14 May 2021

**RE: SUBMISSION ON STATE SIGNIFICANT DEVELOPMENT
APPLICATION: SSD-10464 – 50-52 PHILLIP STREET, SYDNEY**

Figure 1 Proposed Building Envelope – Axonometric View from Phillip Lane (from north-east)

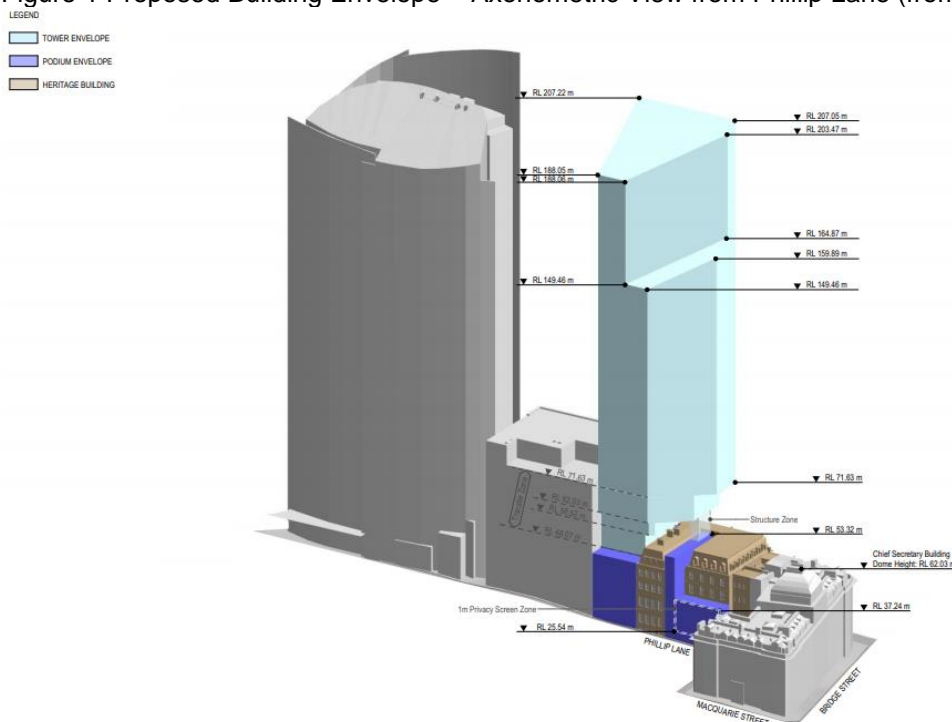
These matters are discussed further throughout this letter. Please consider this submission as an objection and we request that the DPIE consider our concerns in the assessment of this concept proposal.

Figure 3 2D View Sharing Diagram

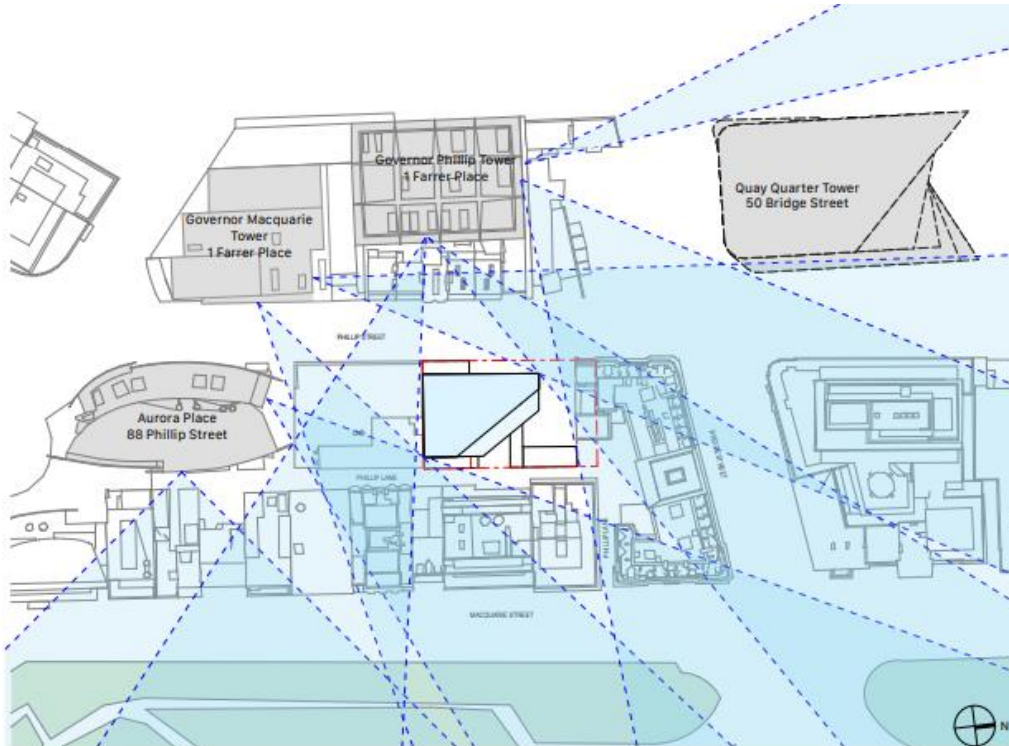
The Design Report accompanying SSD-10464 provides brief consideration of view sharing impacts (one page) which highlights what they appear to understand the impacts to view corridors of surrounding developments situated to the west and south-west (Aurora Place) might be. However, the insufficiency of the VIA and lack of information provided make it difficult to interpret what impacts the proposed building envelope may have on Aurora Place, as well as other surrounding developments. Particularly with regards to what levels these impacts to existing view corridors occur.

From the images above it appears as though the proposed building envelope could have adverse view impacts on Aurora Place which would impact significantly on the amenity of existing tenants. In particular, the proposal appears as though it could obscure the significant existing view corridor from Aurora Place to Sydney Opera House and Harbour (toward the north) and potentially the view corridor to Circular Quay along Phillip Street. Potential amenity impacts such as these further hinder the incentives for the workforce of Aurora Place return to working in the CBD and has spill over effects on surrounding local businesses.

It is requested that further information on view impacts and an updated VIA that adequately analyses and assesses private view sharing impacts to surrounding developments such as Aurora Place as per the SEARs issued by DPIE.

Figure 4 CSPP 2020 SAP Non-Compliances (highlighted)

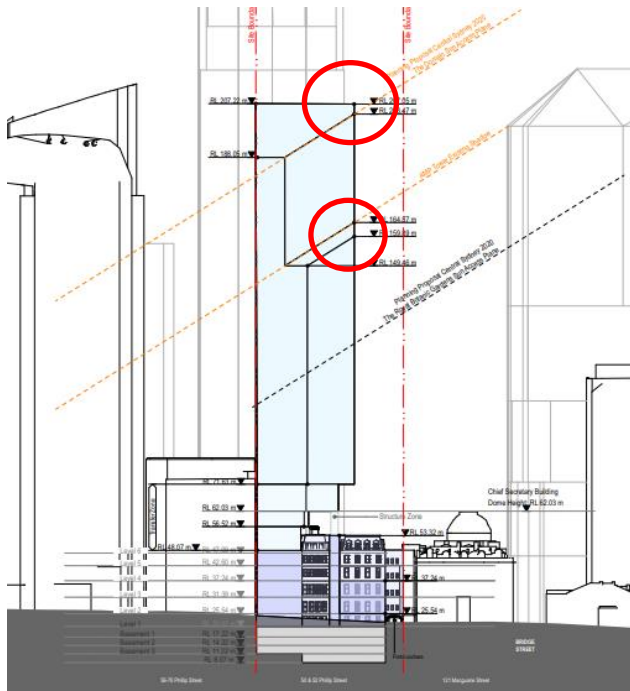
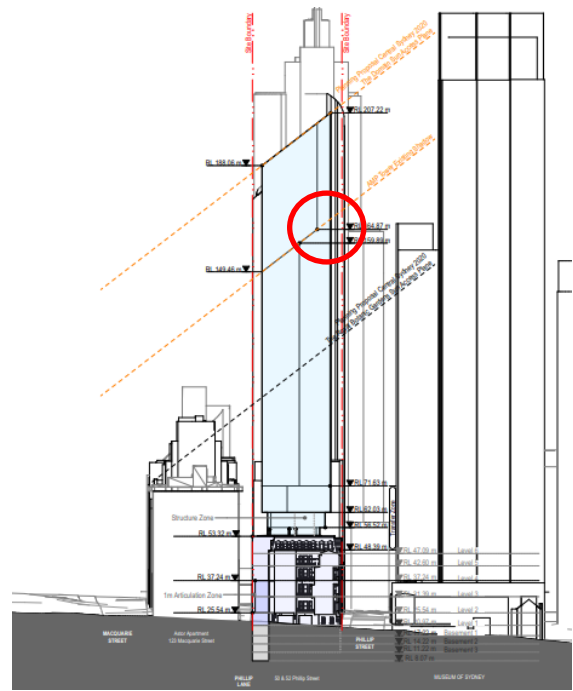
The proposal attempts to justify the non-compliances by indicating that the proposal adopts the slightly modified SAPs established in the Central Sydney Planning Proposal 2020 (CSPP 2020). However, it is noted that the lower massing portion of the proposed building envelope is non-compliant with the modified SAP for the Royal Botanical Gardens outlined under the CSPP. Notwithstanding the proposal's compliance with the CSPP Domain SAP, it is still non-compliant with the requirements under clause 6.17 of the SLEP.

The proposals non-compliance with clause 6.17 of the SLEP and CSPP Royal Botanical Garden SAP are illustrated in the figure below.

The non-compliances with both the SLEP and CSPP SAP controls could cause adverse amenity impacts to existing tenants at Aurora Place with regards to overshadowing. The proposed building envelope and Aurora Place are similar in height. As such, it is considered that any reduction in height to achieve compliance with the SLEP SAP controls will improve solar and daylight access to Aurora Place, particularly to the upper floor tenancies.

It is requested that the applicant provide information for their non-compliances with the SLEP controls, particularly in terms of providing an overlay which demonstrates the height breach (similar to Picture 5 above but for the SLEP controls). In addition, it is requested the applicant further consider complying with these controls to enable greater solar and daylight access for Aurora Place, thus improving the amenity for existing tenants.

Figure 5 Tower SDCP Compliant Building Envelope and Proposed Building Envelope Comparison

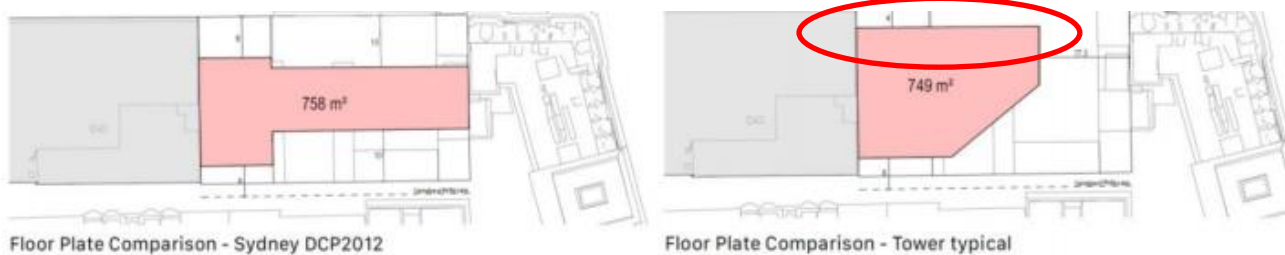
In particular, the proposal is non-compliant with the 8-metre weight average setback control to Phillip Street and the 10 metre setback requirement to the State heritage listed building at 50 Phillip Street. The applicant has provided a comparison of an SDCP compliant envelope and the proposal in which we have marked up the non-compliance (refer figure below).

In our view, the proposed non-compliant envelope which breaches the required Phillip Street and heritage item setback could adversely impact on the amenity of Aurora Place situated to the south in terms of reducing solar and daylight access (particularly overshadowing to the western façade), and impacting upon the existing view corridor to the north along Phillip Street (as previously discussed).

There are also concerns that the Phillip Street setback non-compliance results in a longer building interface which presents to the southern boundary and effectively Aurora Place. In addition to the beforementioned amenity impacts, this could result in additional privacy impact considerations for future detailed designs.

As such, it is requested that the applicant and DPIE give further consideration to a compliant building envelope (in terms of setback) and mitigating adverse overshadowing, daylight, and view sharing impacts as this will provide improved amenity to Aurora Place.
